**SSD-10468 EIS EXHIBITION
WAREHOUSE AND CUSTOMER FULFILMENT CENTRE
74 EDINBURGH ROAD, MARRICKVILLE**

TfNSW has reviewed the EIS and provides the following advisory comments for the Department's consideration in **TAB A**.

**Brendan Pegg
Senior Land Use Planner
Planning and Programs, Greater Sydney Division**

**20.0m ARTICULATED
 VEHICLE SWEEP PATHS**

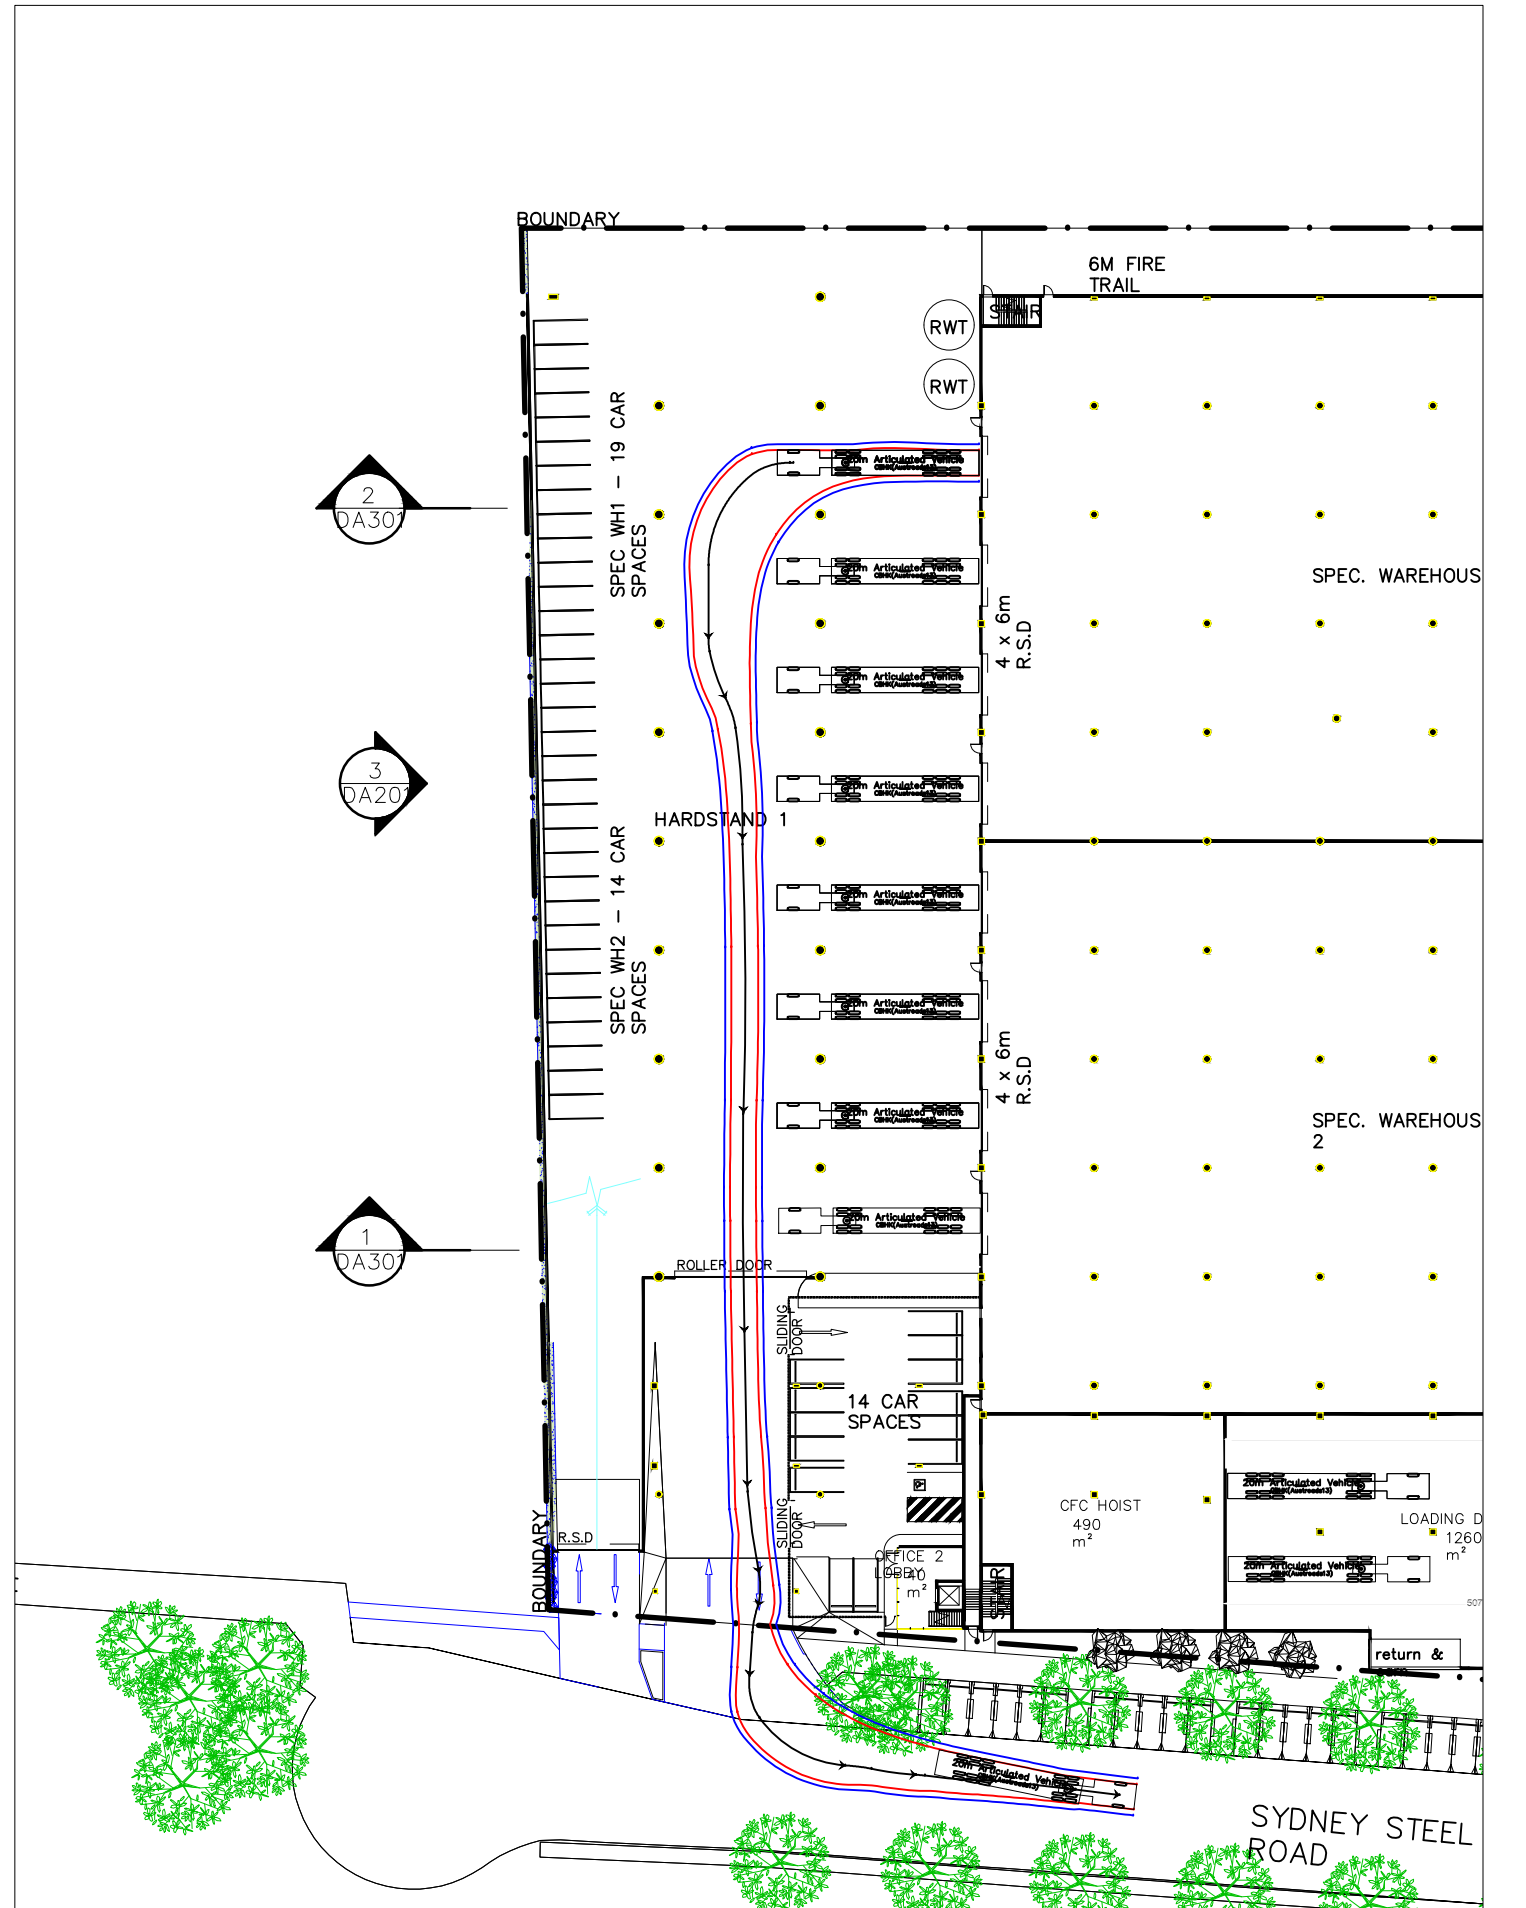
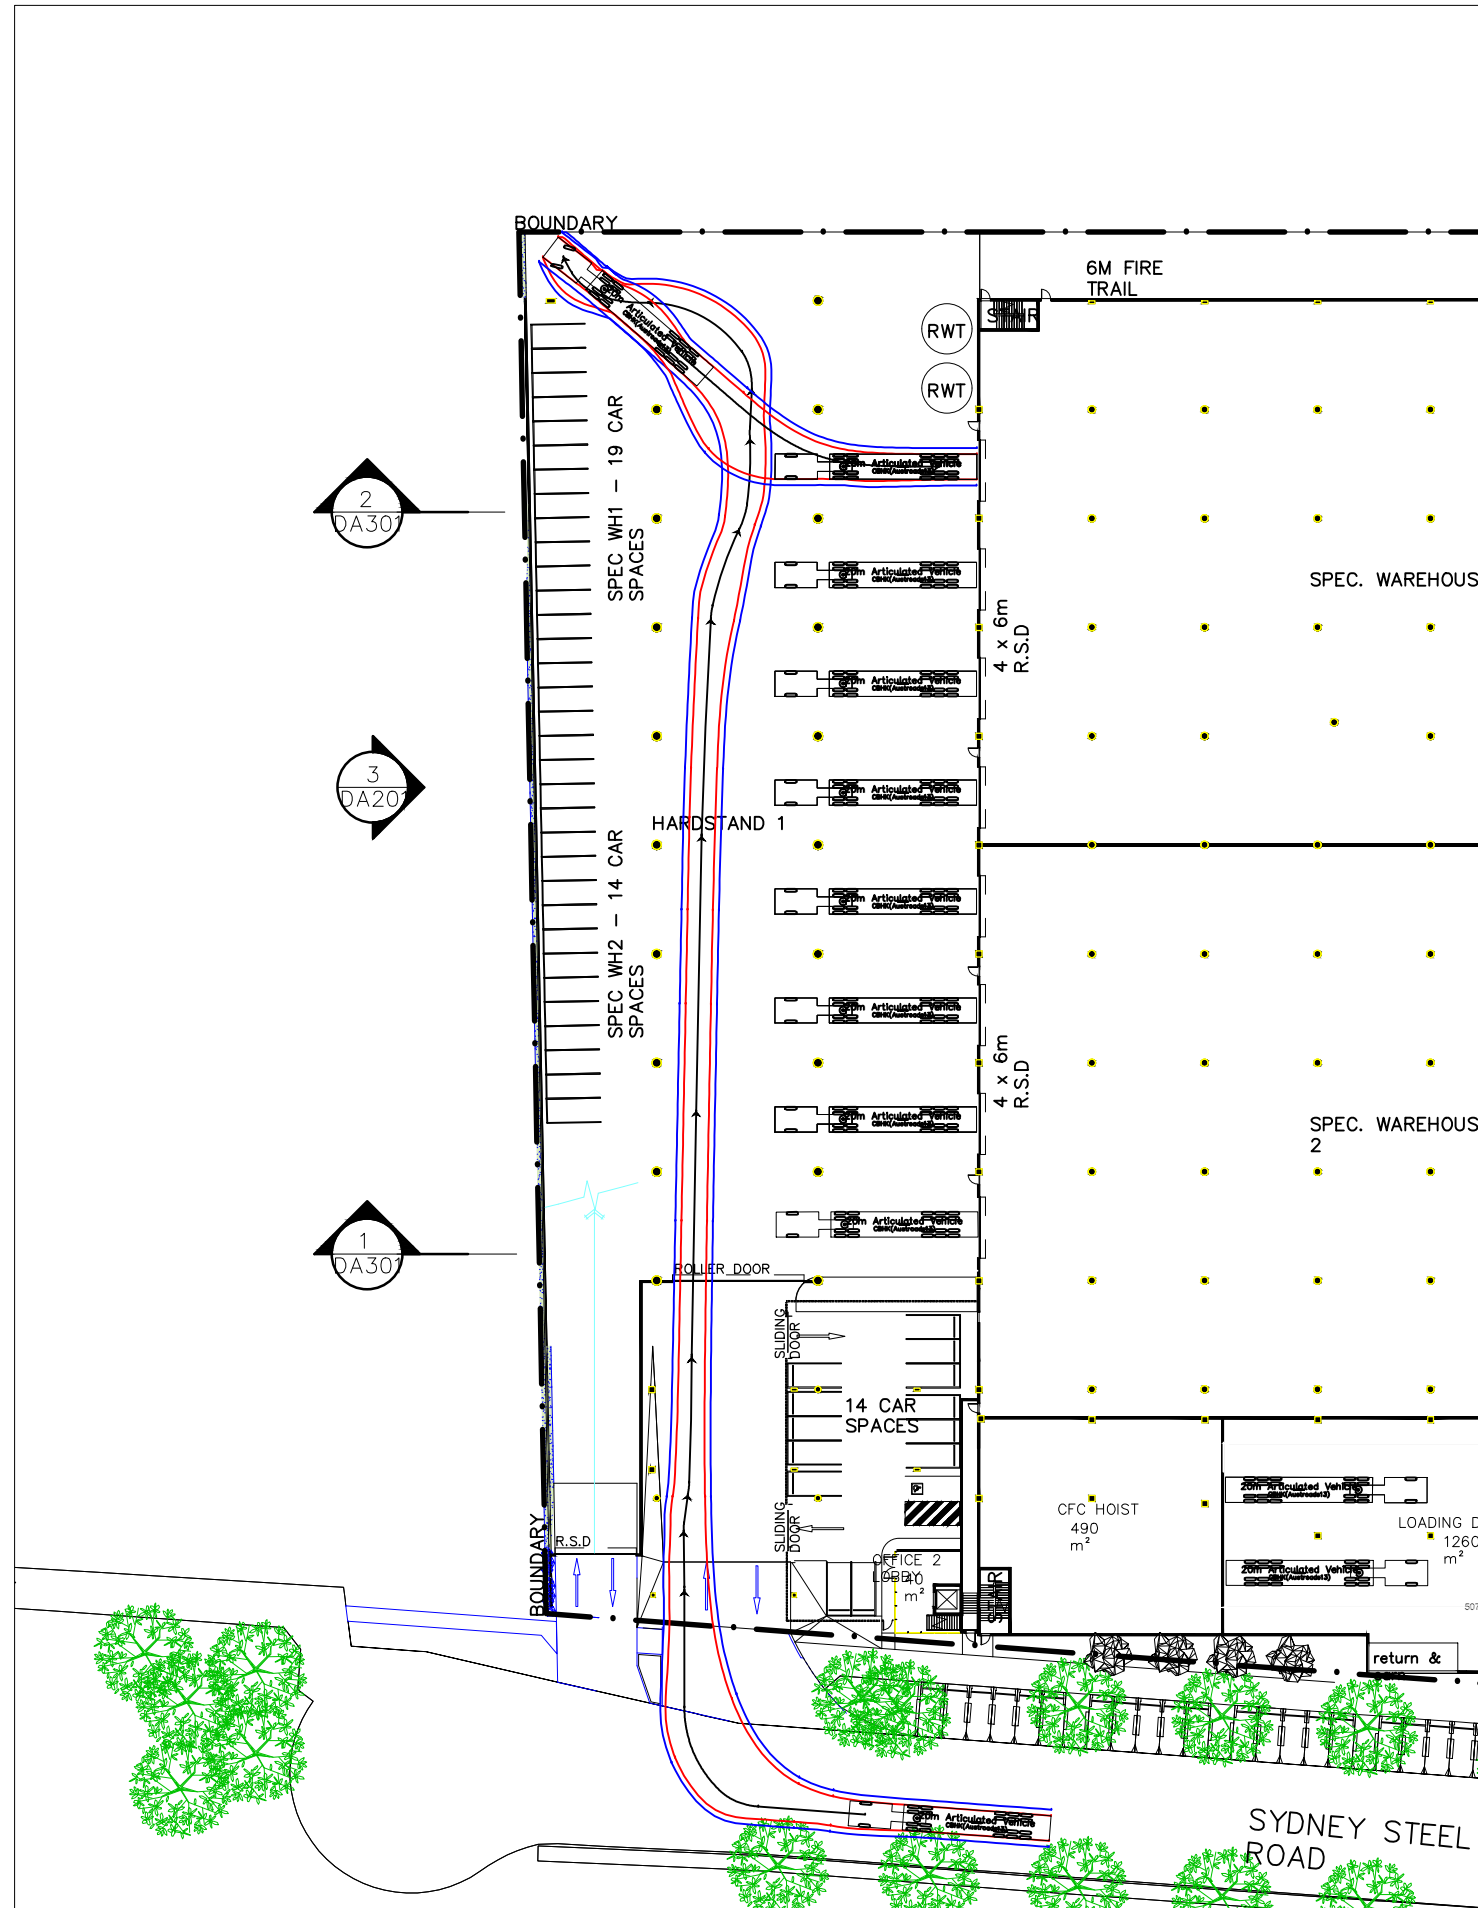
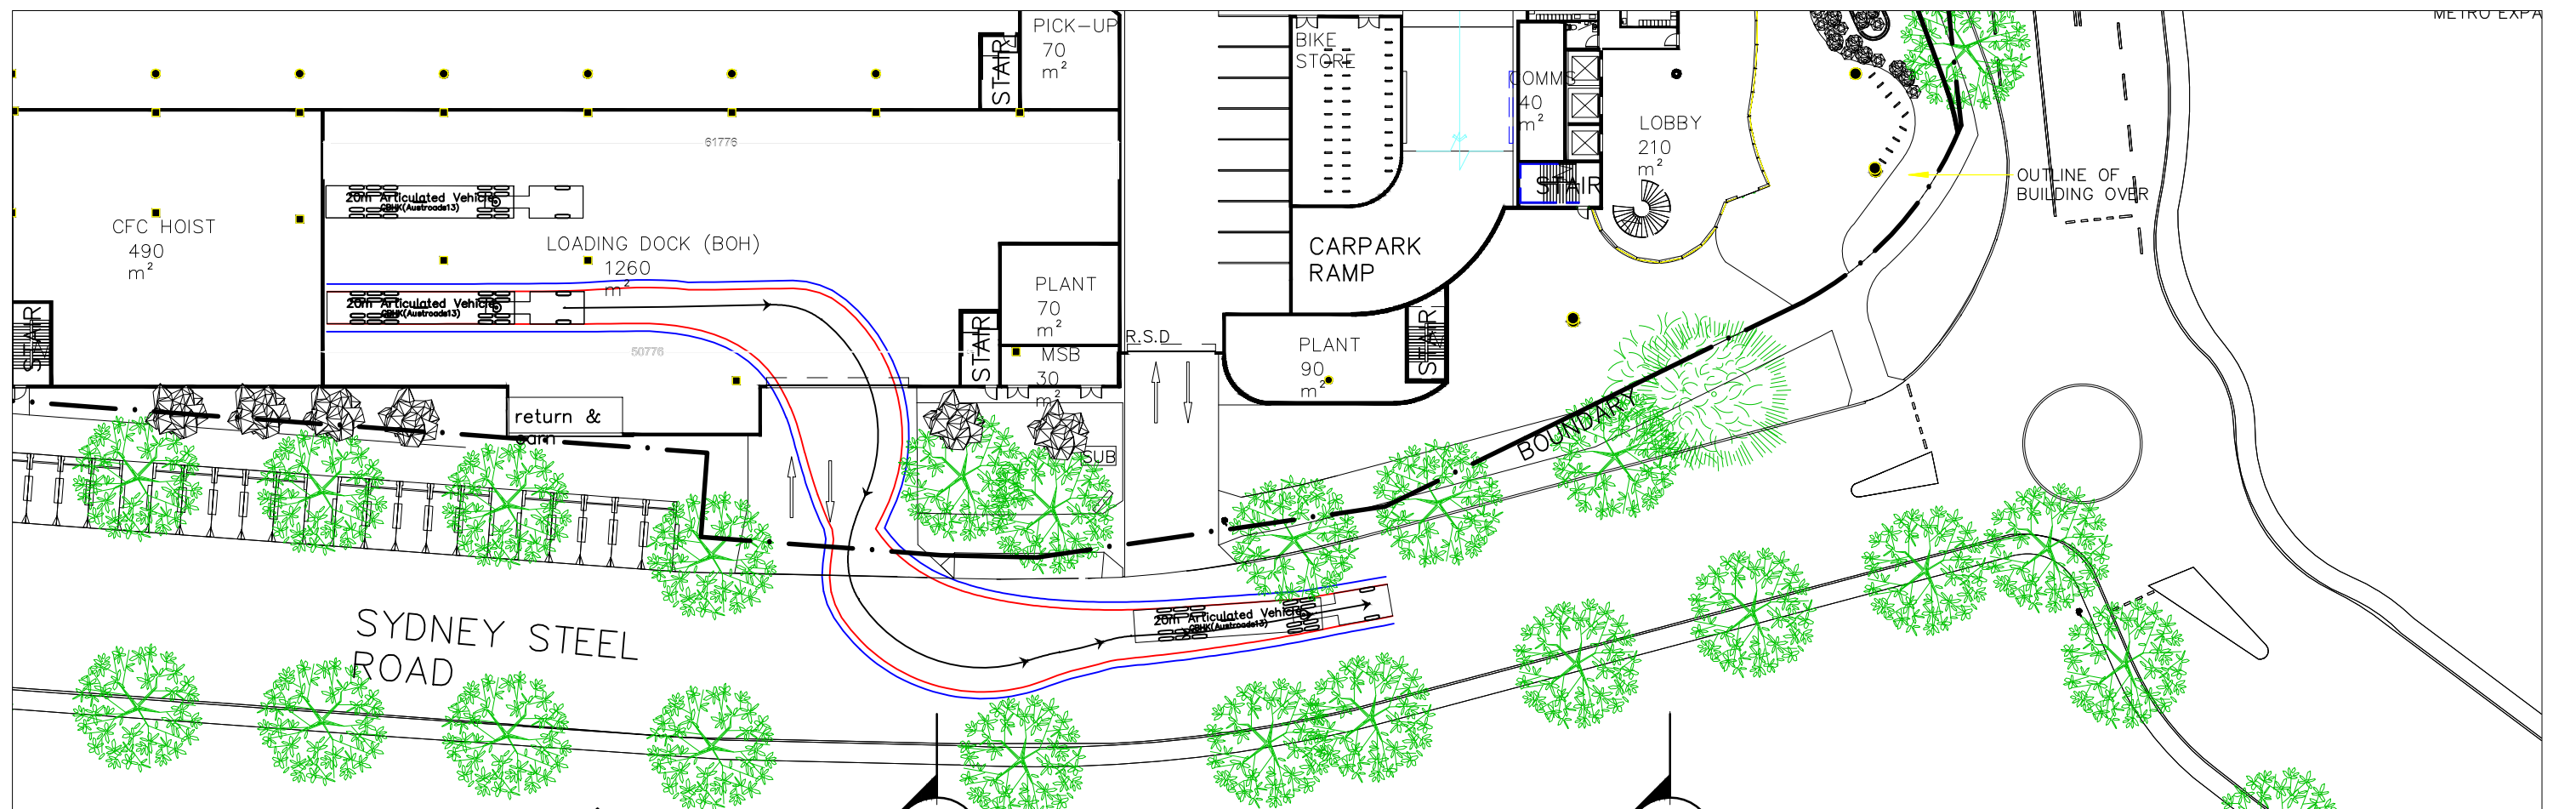
Section 3.20 states that "*Deliveries to the customer fulfilment centre will be made by semi-trailers up to 20 metres long*". TfNSW questions the suitability of the local road network to accommodate for such vehicles.

TfNSW has reviewed the internal swept paths for the site and notes that the semi-trailer movement (Sheet 9 in the TIA) is only illustrating the end docking space being utilised. For the other seven loading dock spaces to be utilised, TfNSW believes that the movements may encroach on the car parking spaces.

The proponent is to review the swept path of all semi-trailer movements to ensure that the vehicles can operate without impacting the proposed car parking areas.
